11 December 2019

**SSD-8707 Submission Response to Stage One Ivanhoe Estate, Macquarie Park state significant development application**

Figure 27 | Building A1 separation to approved development at 137-143 Herring Road (Base source: Stage 1 Architectural Plans)

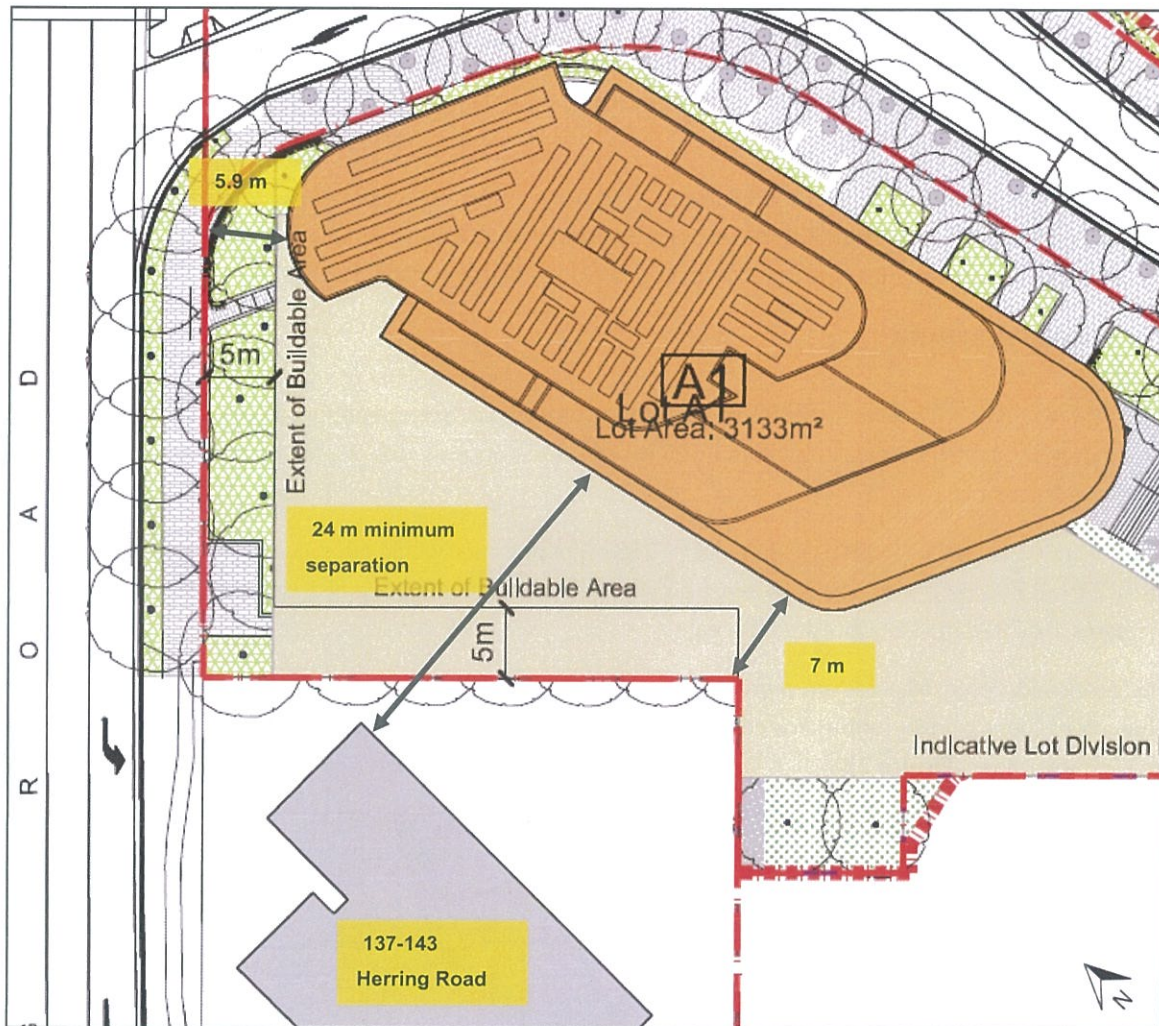
Re building A1, I continue to object to the height, inadequate setbacks, design and overshadowing of other buildings.

The A1 setbacks on Main Street are inadequate to allow the landscaping proposed: The various new reports state Main Street will have landscaping. How can you do adequate landscaping when A1 provides a setback of 3.8m or an average of 2m with Main Street. There needs to be a much bigger setback for these buildings to make Main Street more majestic and appealing to give people pride in their neighbourhood. The entrance to the estate needs to be a feature not a 3.8meter setback to a tall apartment tower.

The overshadowing by A1 for the building on 137- 143 Herring Road is also not acceptable.

Figure 33 | Shadow diagram 9 am midwinter (Source: Applicant's RRTS)

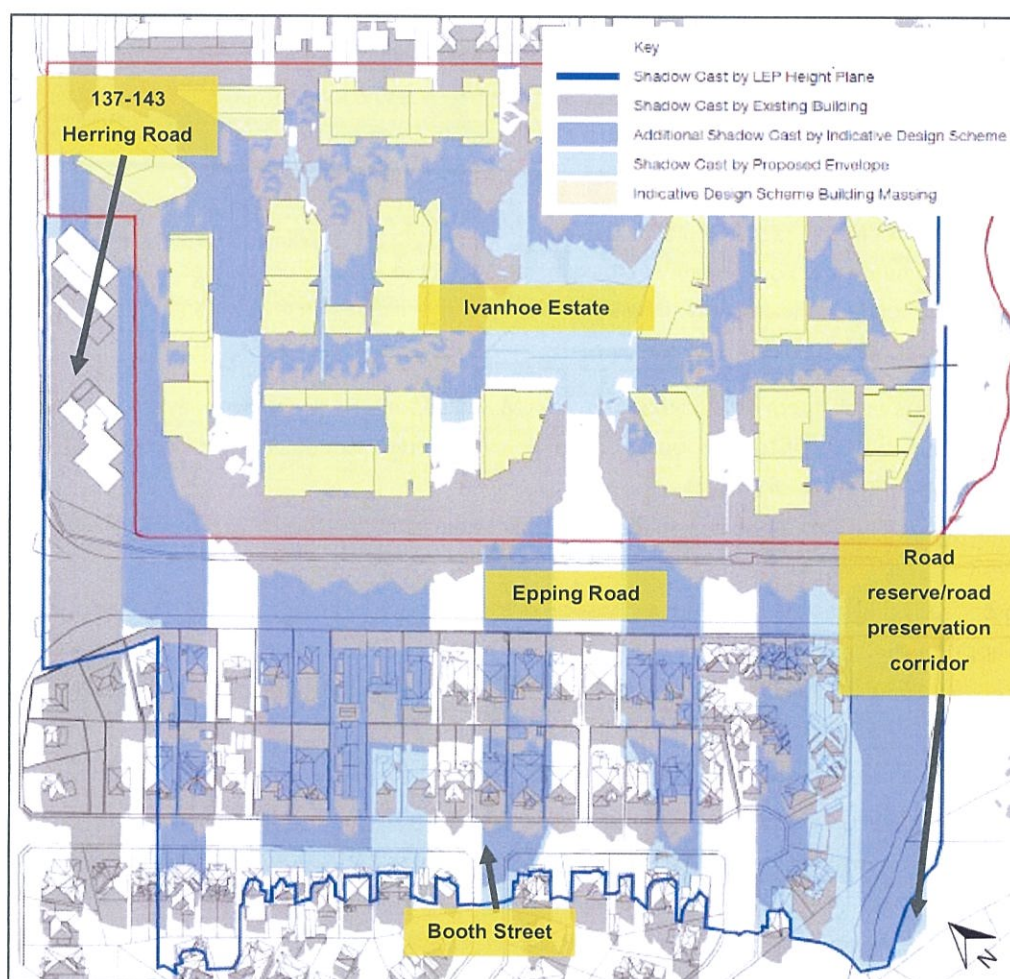
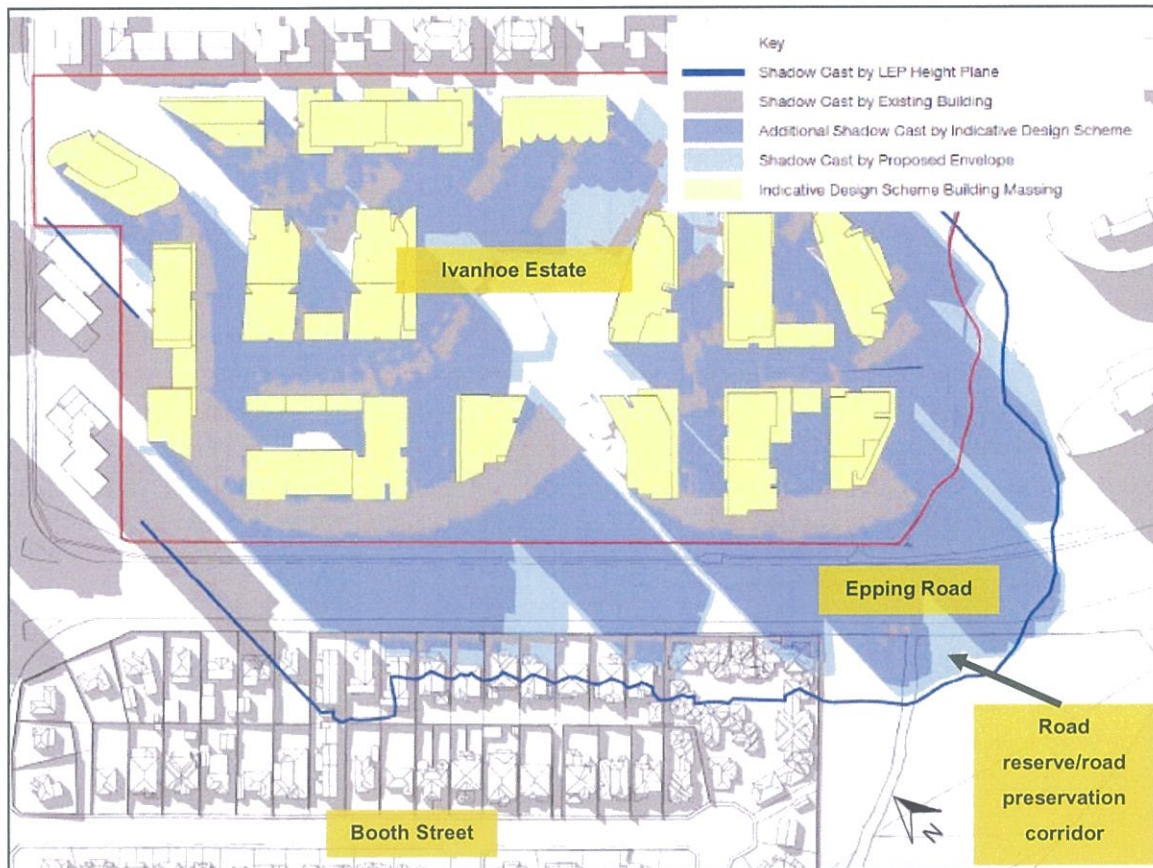
The A1 building represents the gateway to the estate and is the most north/east aspect. It would be better to have a less tall building at this location which will not overshadow the whole estate, including the village green and which will create a ghetto at the entrance. The C1 building is also too tall as it will cause overshadowing of large parcels of the site from the morning easterly sun and some northern sun. While you will include open spaces and play areas these will not be desirable places to use as they will have limited solar access.
